SP-1.1

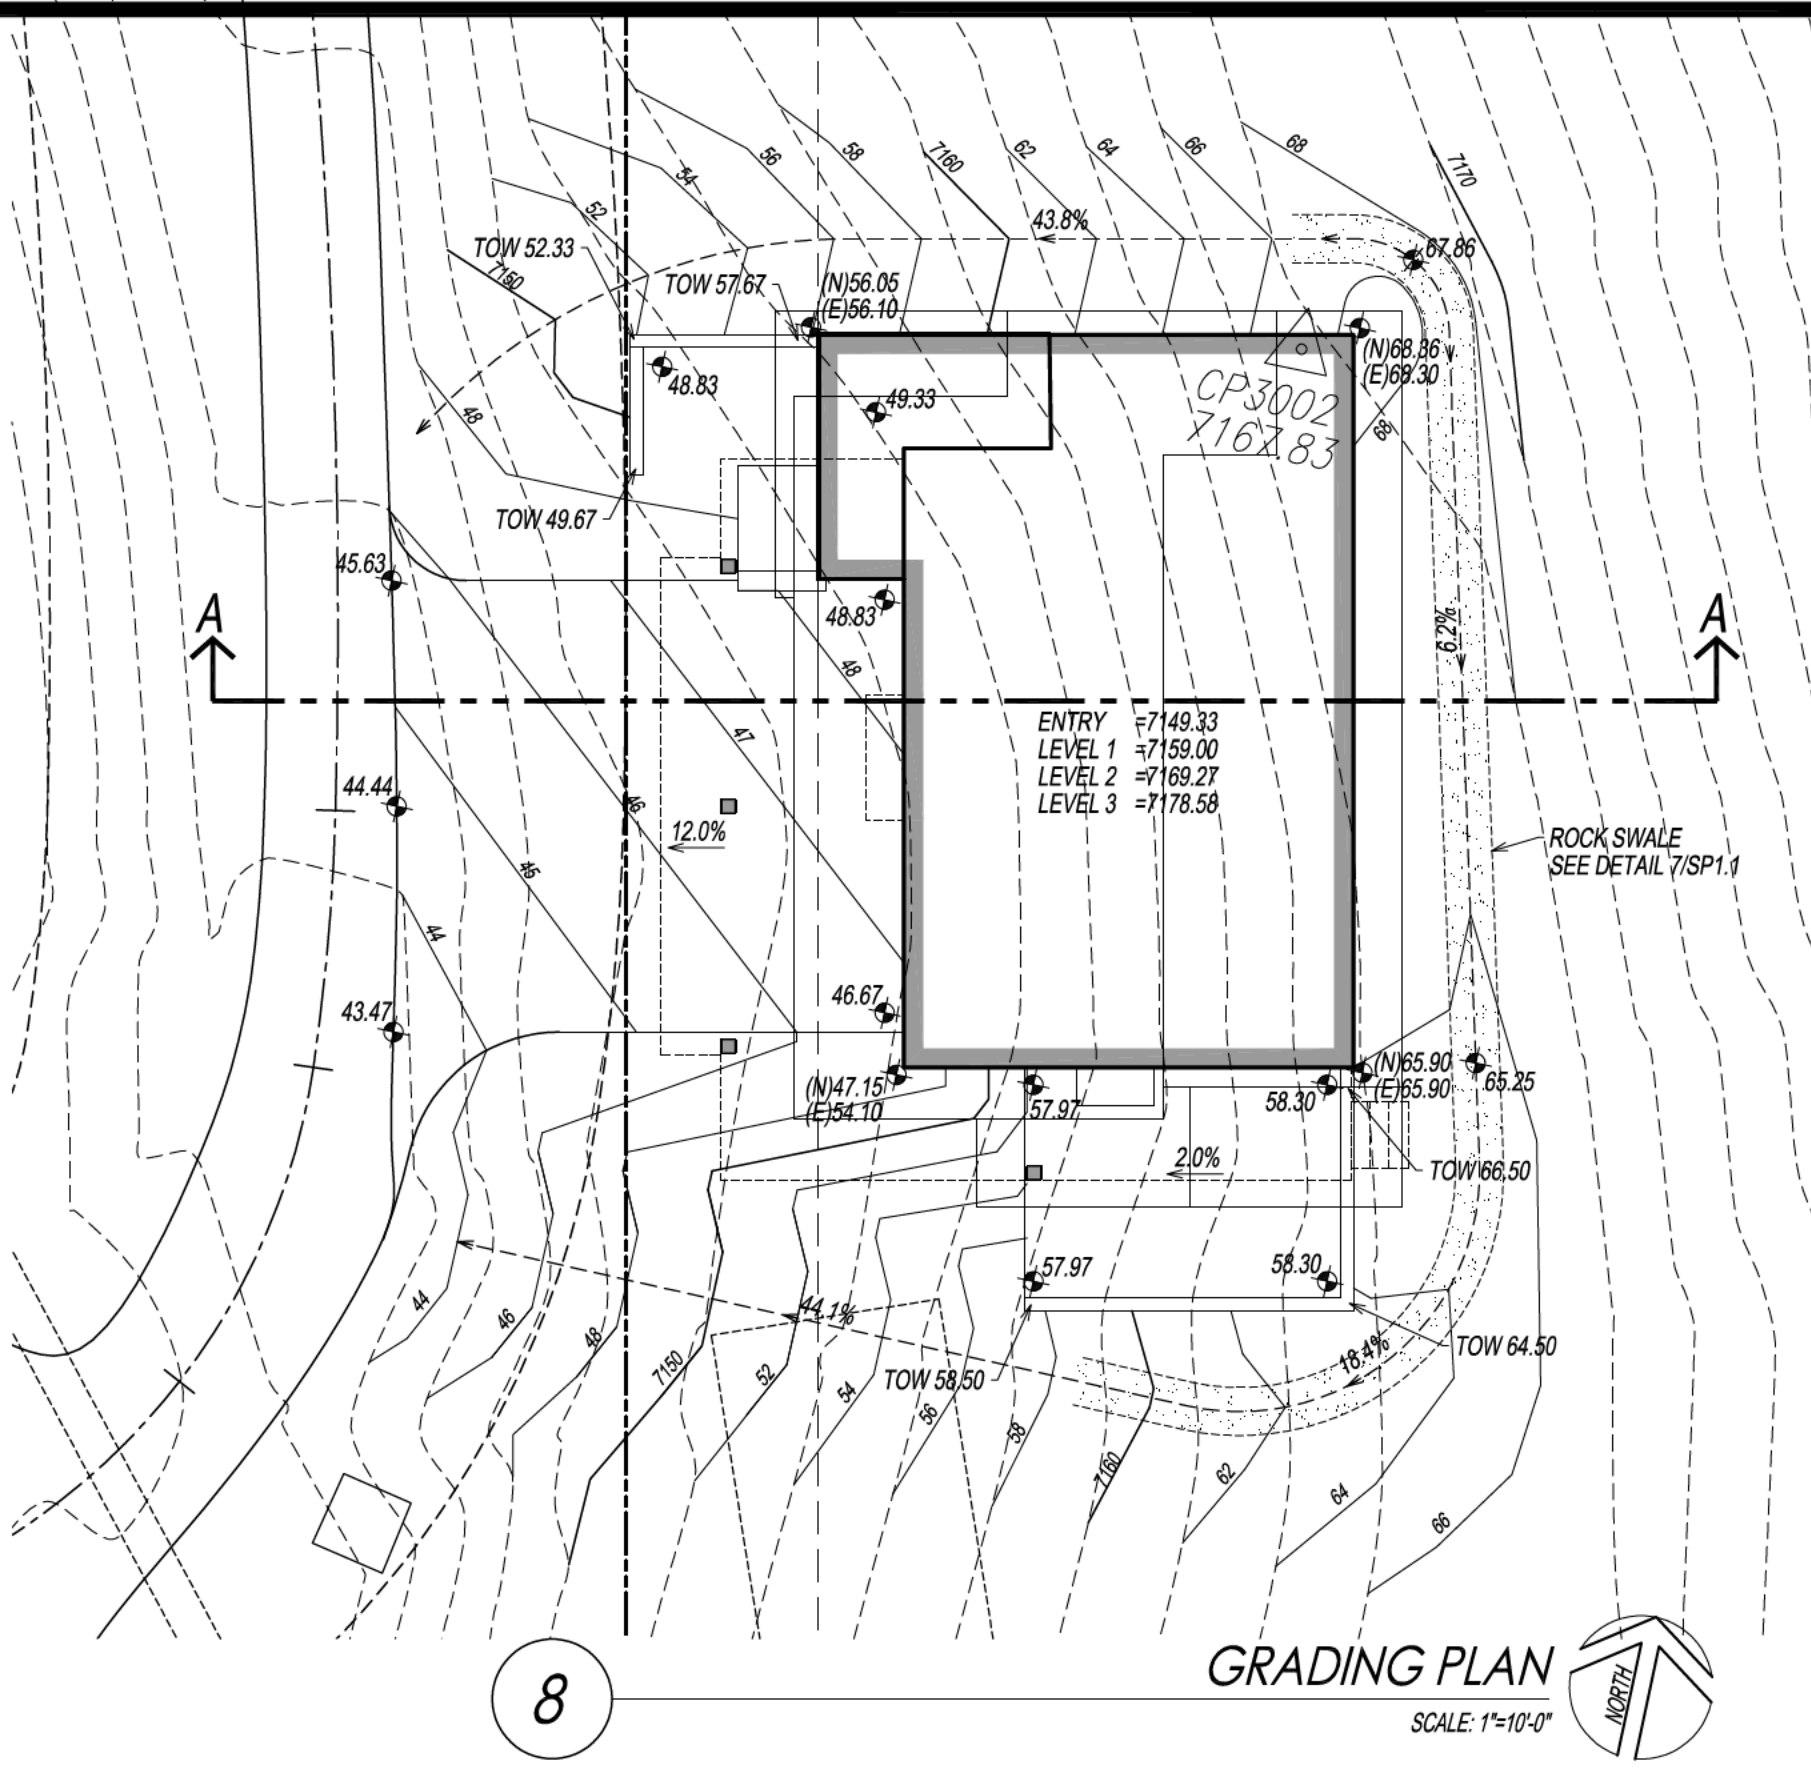
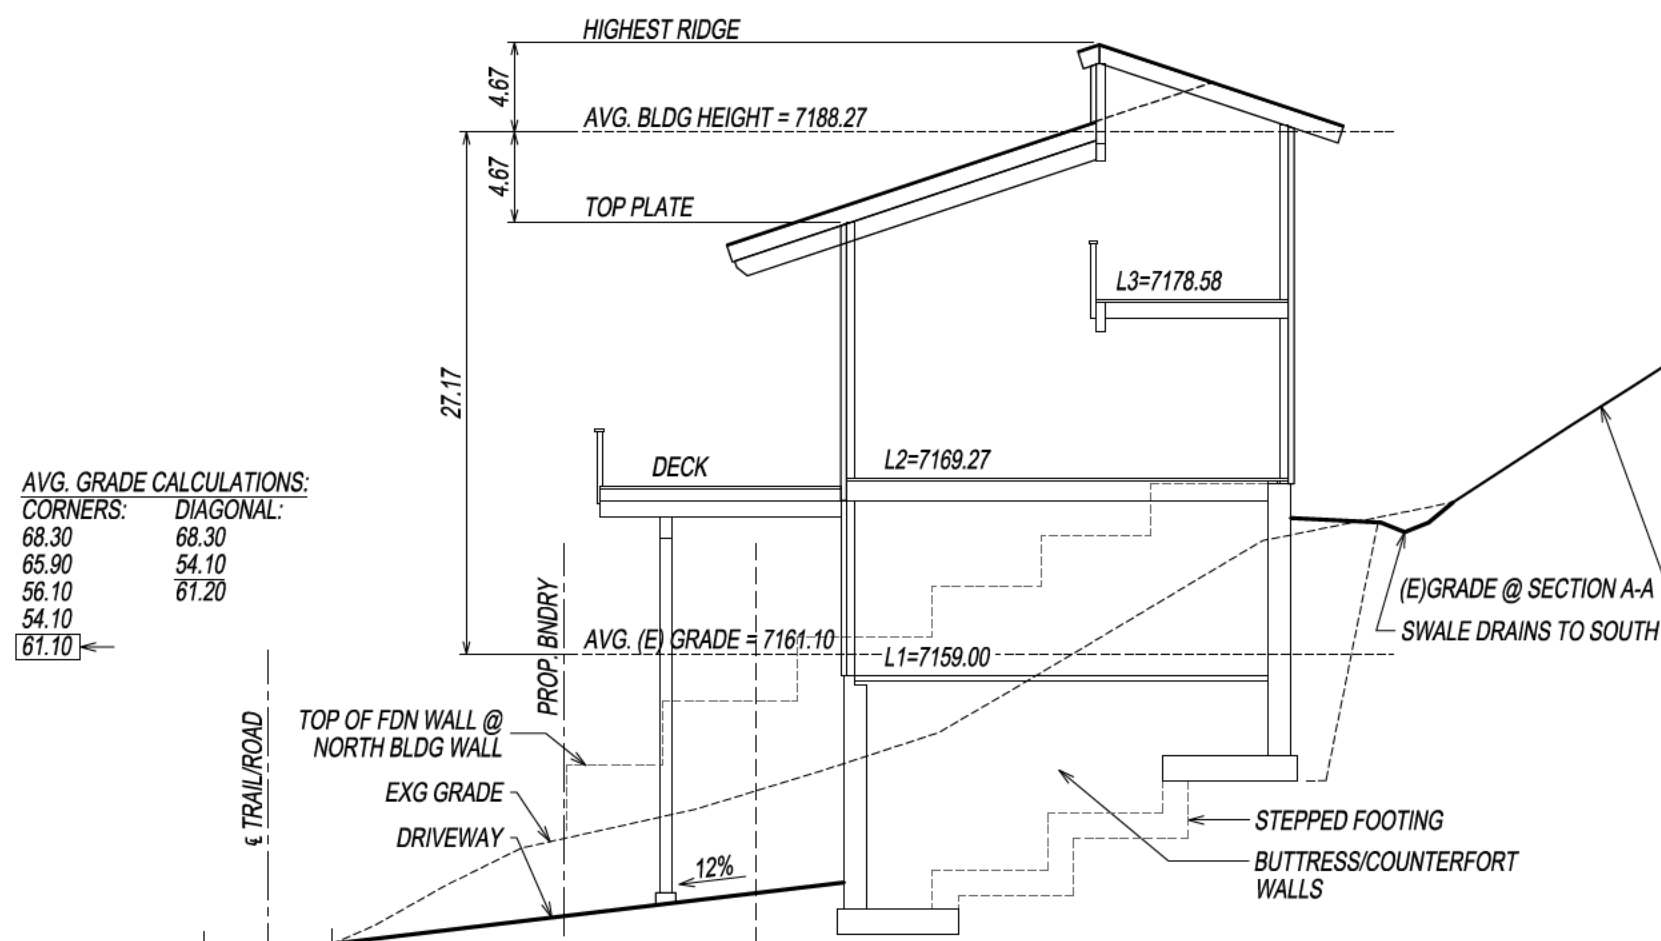
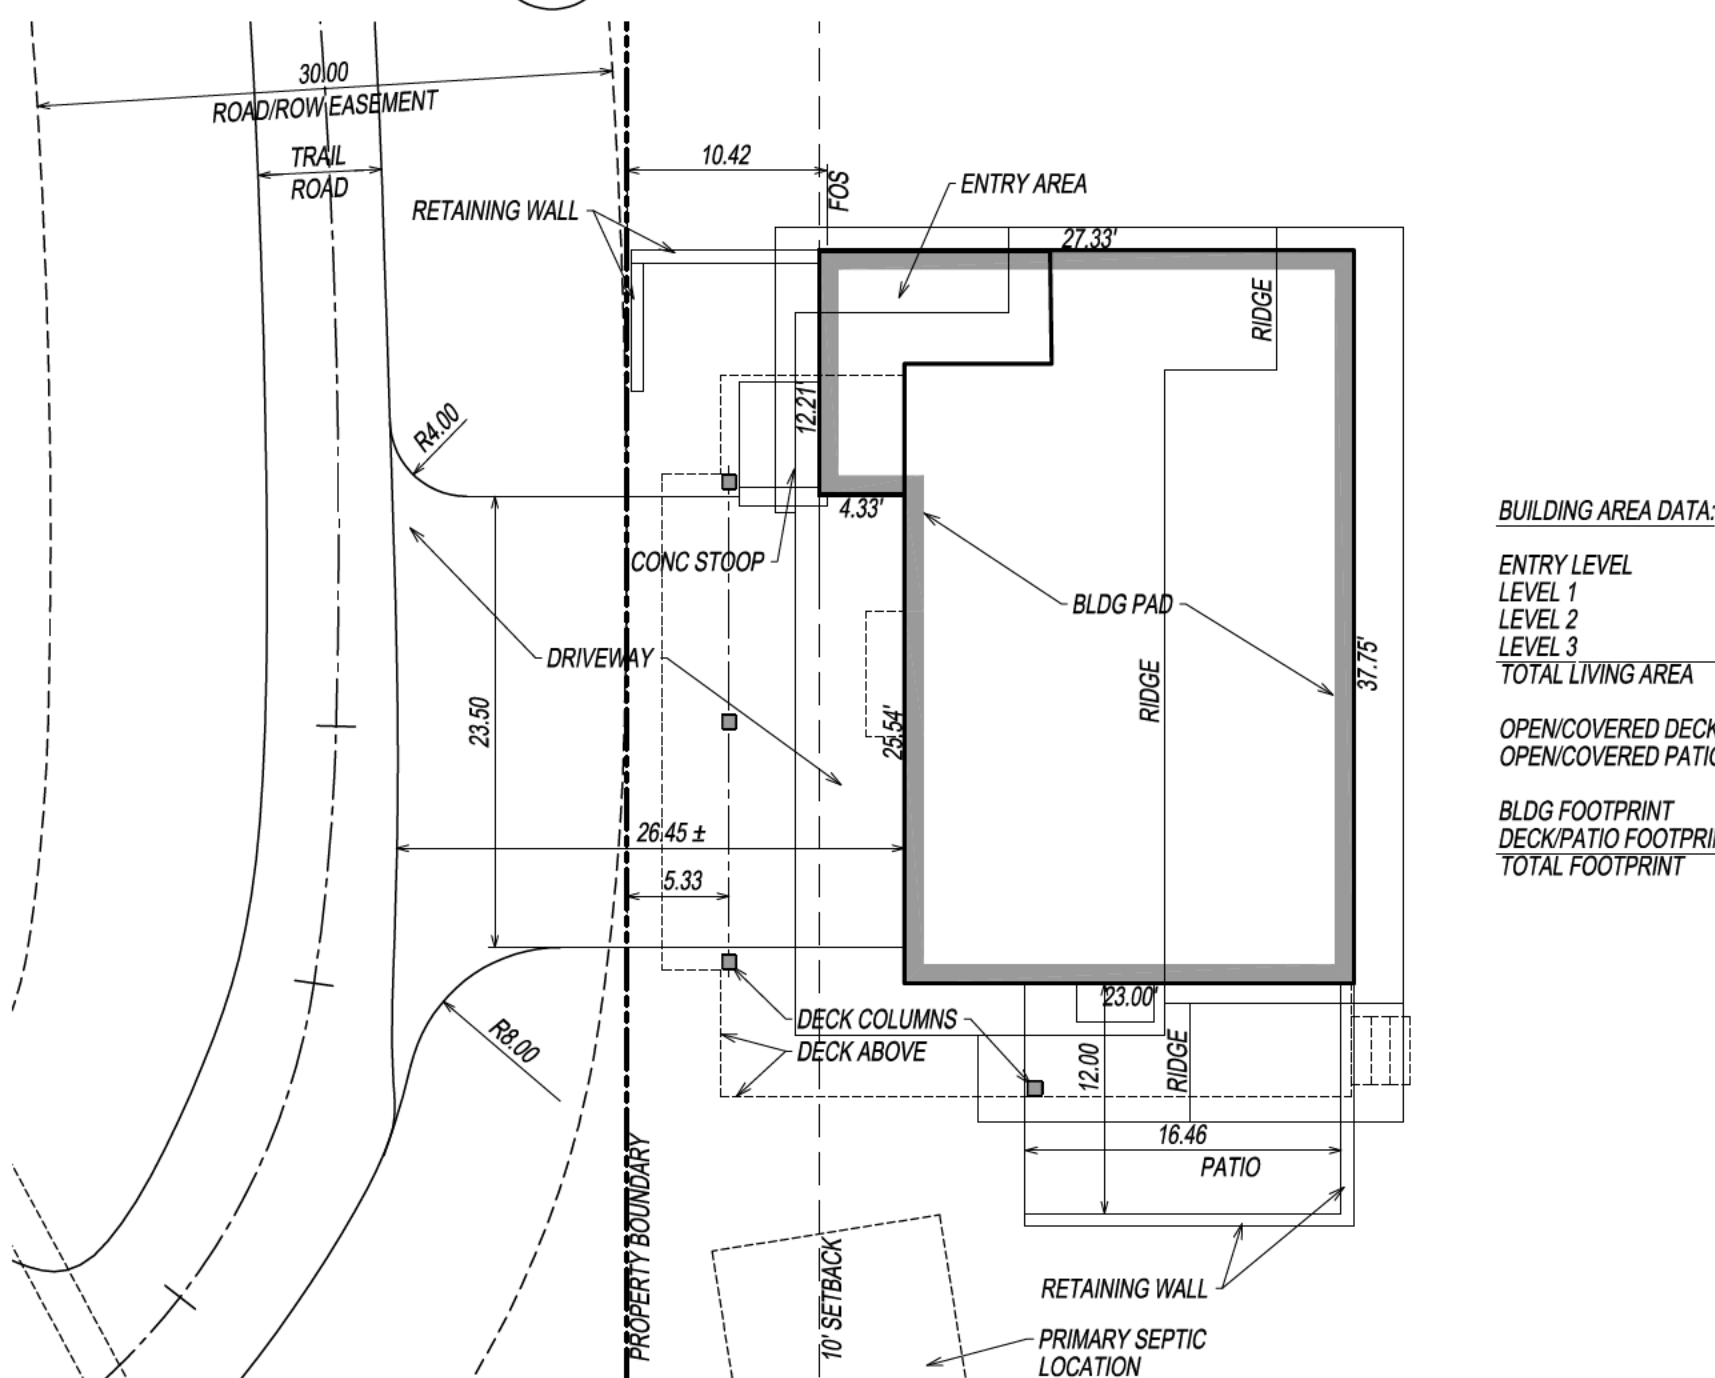
Please revise / add notes per comment from Colorado Geologic Survey (on EDARP), as well as per the recommendations within the soils & geology report submitted.
